From: ENVU Biodiversity and Land Use
Sent: 14 January 2026 15:31
To: Planning ContactCentre
Subject: 2025/93438 at location Arena Young Peoples Centre, Moorlands Road, Dewsbury, WF13 2LF

Please see ecological commentary below:

ASSESSMENT OF  
 EXISTING TREES  
 INC TREE PROTECTION

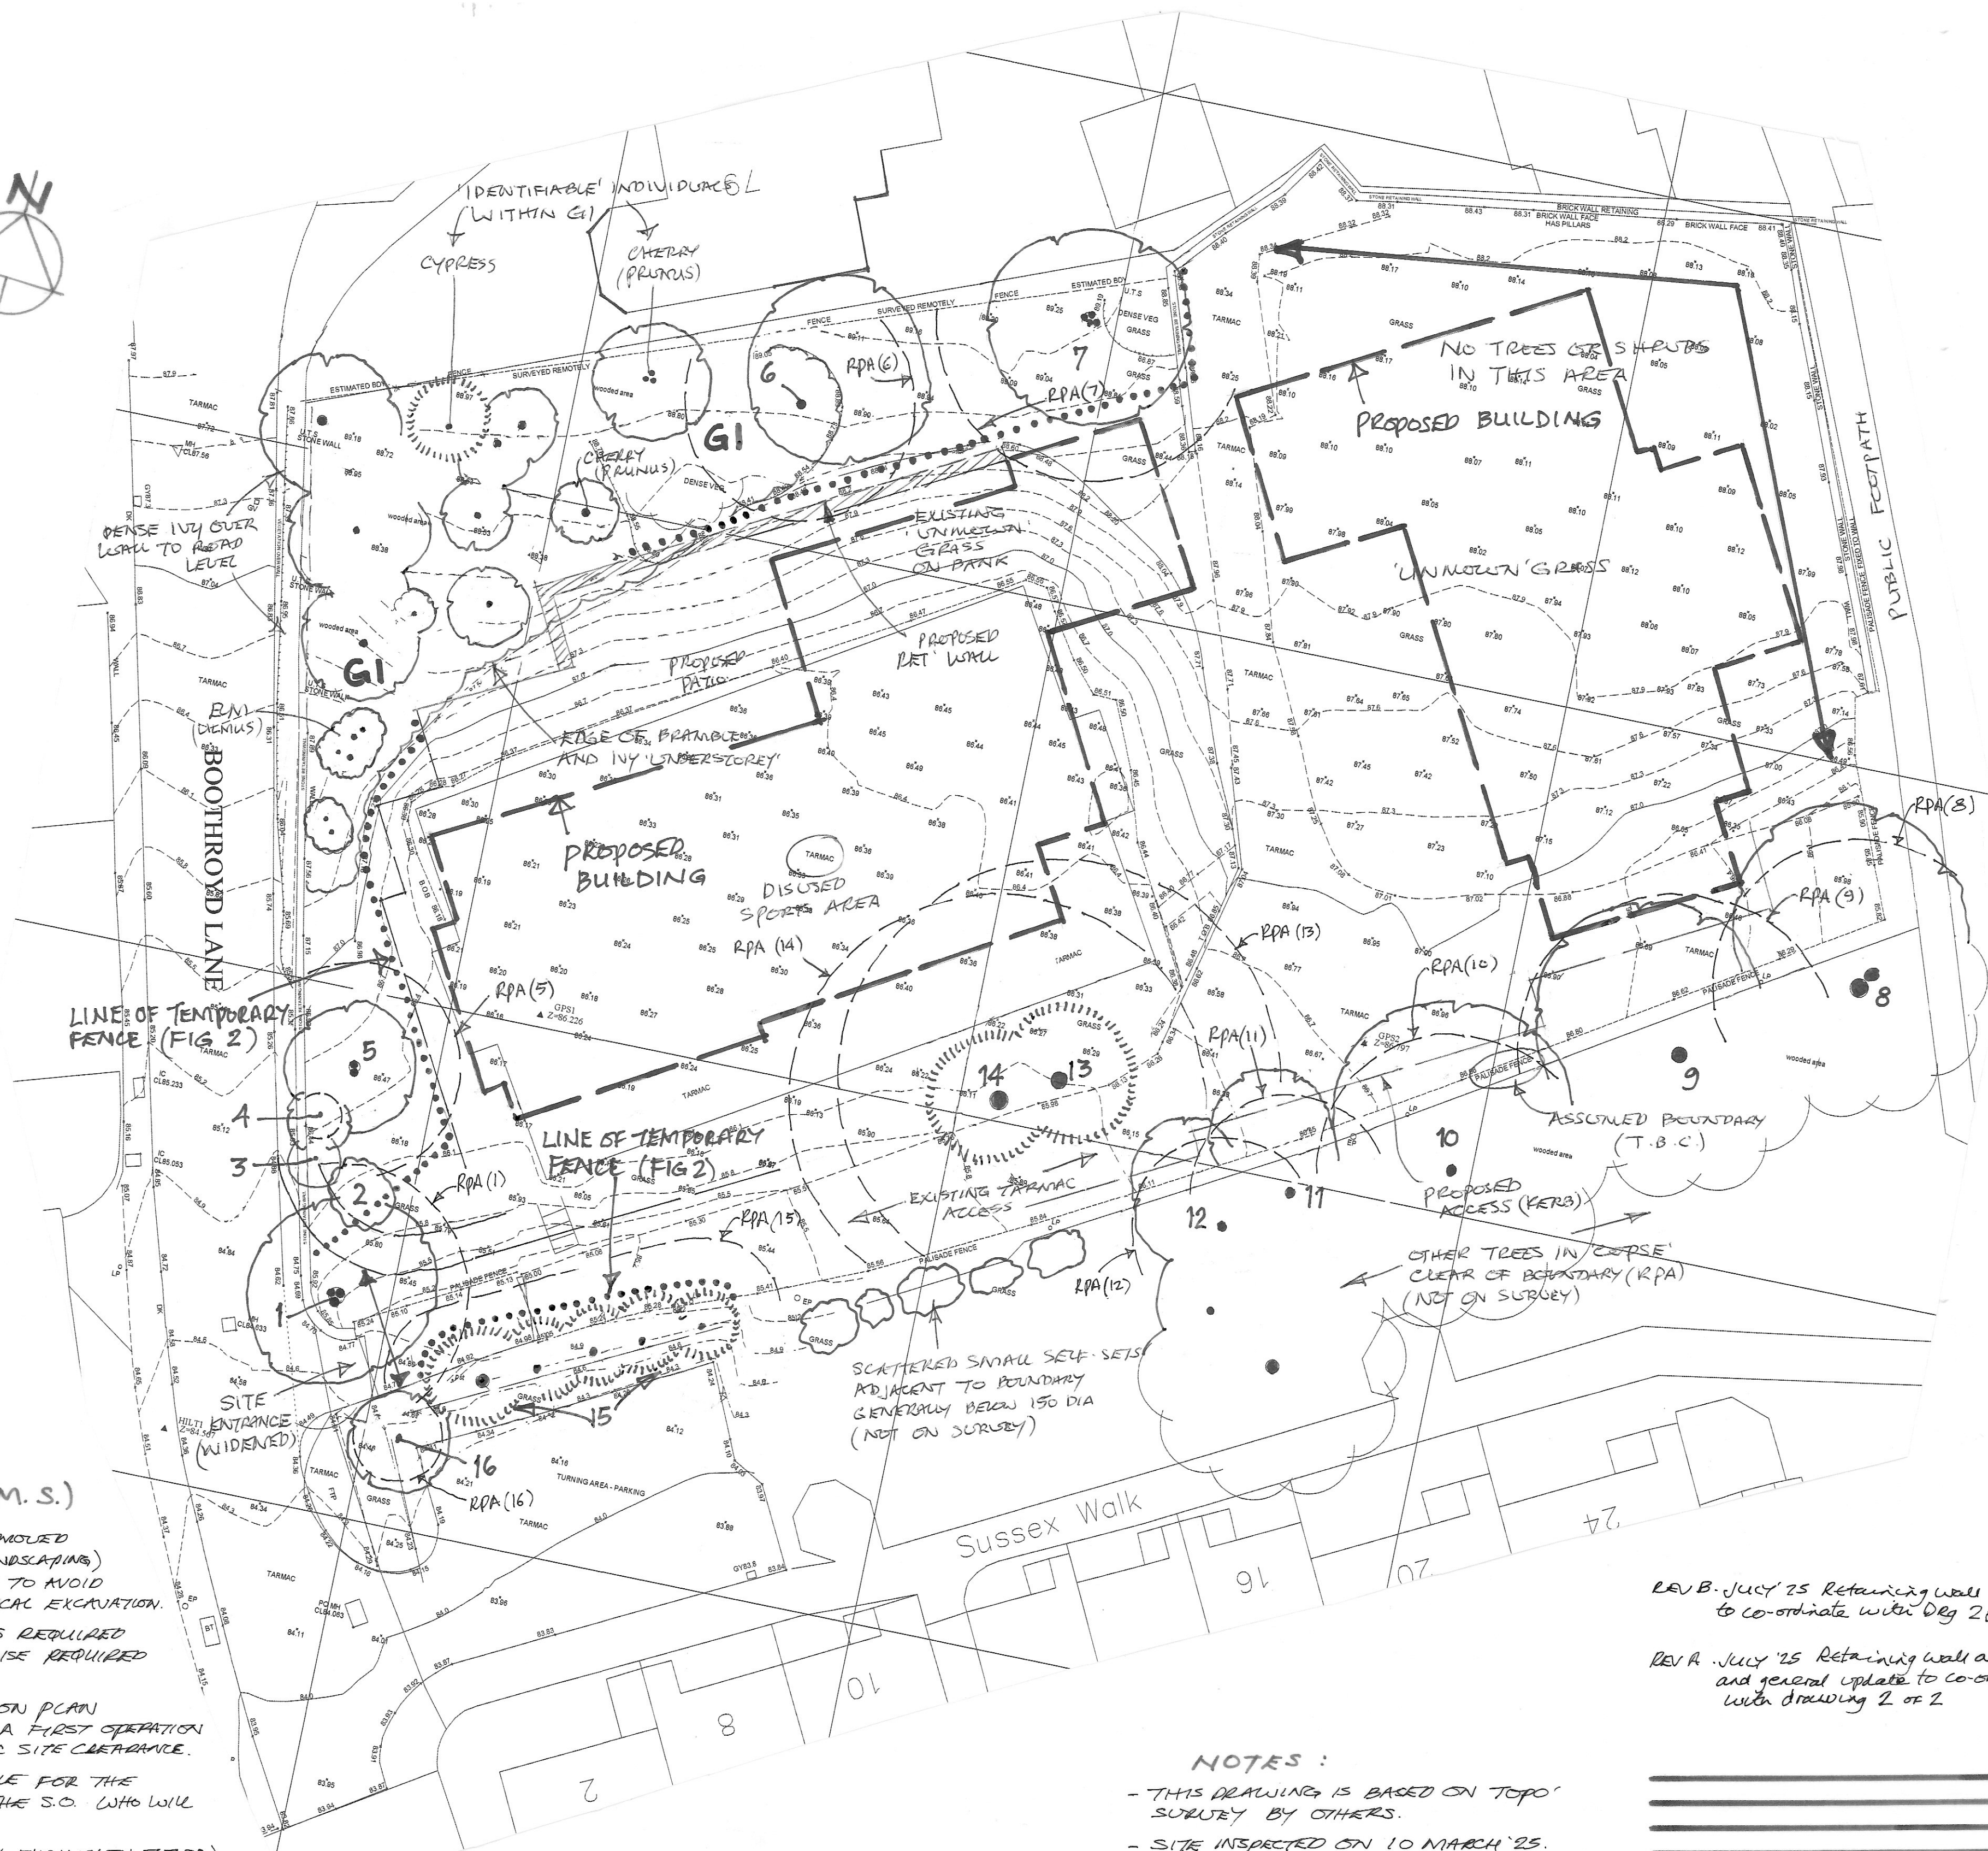
The site has suitability for GCN, badgers, reptiles, birds, and hedgehogs. Trees BT1, BT2, and BT3 have some suitability for roosting bats, and the site had suitability for foraging / commuting bats. Should the removal of the trees be part of the works further surveys / consideration would be required.

Recommendations for the species mentioned have been provided. A CEMP will be used to cover these recommendations, as well as tree protection measures for BT1-3, lighting strategy, and enhancements.

Tree protection for Trees BT1, BT2, and BT3

A Hedgerow and Tree Protection Plan detailing measures for the protection of trees and hedgerows during the works will be submitted to and approved by the LPA prior to the commencement of works on site, including site clearance and delivery of materials.

Hedgerow and tree protection measures will include temporary fencing for the protection of hedgerows in accordance with BS 5837:2012 Trees in relation to design, demolition, and construction – Recommendations. Any alternative fencing type or position not in accordance with BS 5837:2012 will be agreed in writing by the LPA prior to the start of development.

The root protection fencing will define the works exclusion zone around hedgerows and trees. Activities liable to be harmful to hedgerows and trees are prohibited within this exclusion zone, unless agreed in writing with the LPA. The approved hedgerow and tree protection measures will remain in place until the completion of development or unless otherwise agreed in writing with the LPA.
